Consultation Response from KC, Conservation & Design**2023/93170 Chain Farm, Chain Road, Slaithwaite, Huddersfield, HD7 5TZ****Listed Building Consent for replacement conservatory roof****Date Responded: 24.11.2023****Responding Officer: Sue Brooks****Responding Ref: CV 5/312**

4 Proposed Roof Plan
1 : 50

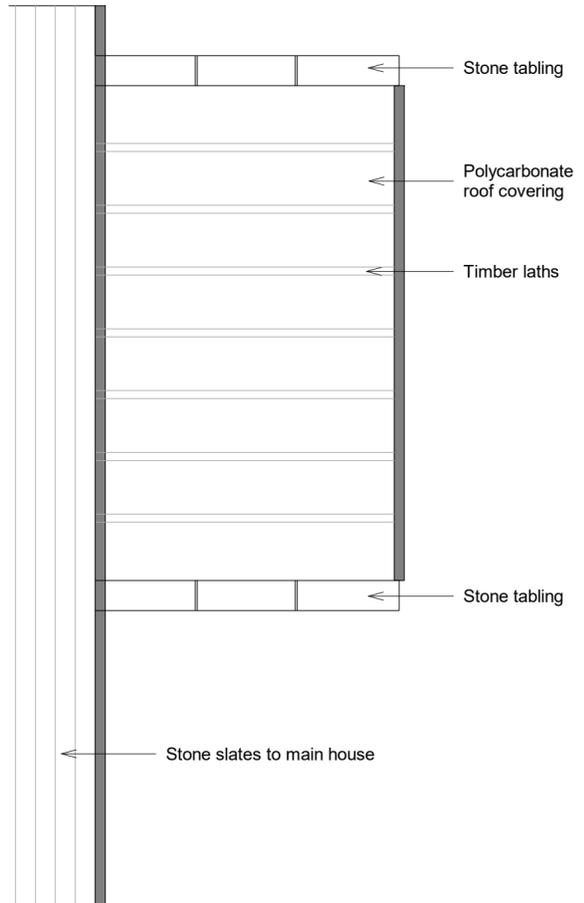
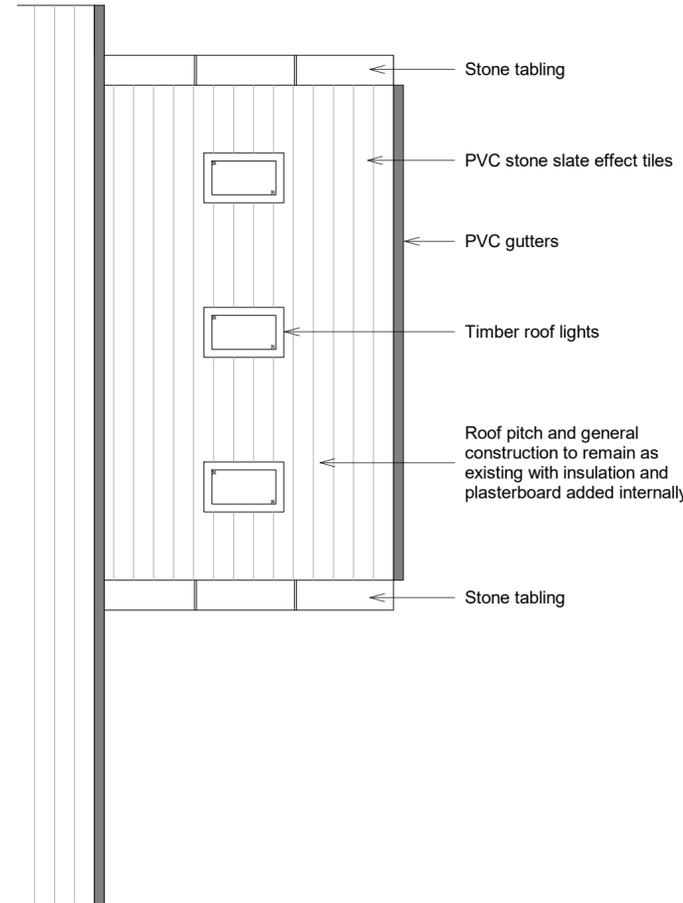
The existing conservatory is timber framed with stone parapet side walls and a polycarbonate roof set into a timber frame. The applicant proposes to replace this roof covering with lightweight artificial moulded PVC blue slates, with PVC gutters and three conservation style roof lights.

The Conservation and Design Team has no objections to the replacement of the existing roof covering and insertion of flush conservation rooflights. However, we have concerns about the proposed roof covering. The roof of the former barn is covered in natural stone slates, which are a typical vernacular material for this age and type of building within the Colne Valley. Introducing artificial PVC slates will detract from this character, particularly given the prominent nature of this roof pitch and its proximity to the footway.

We would recommend that more traditional roof coverings are explored and we would welcome reconsideration of this element of the proposal.
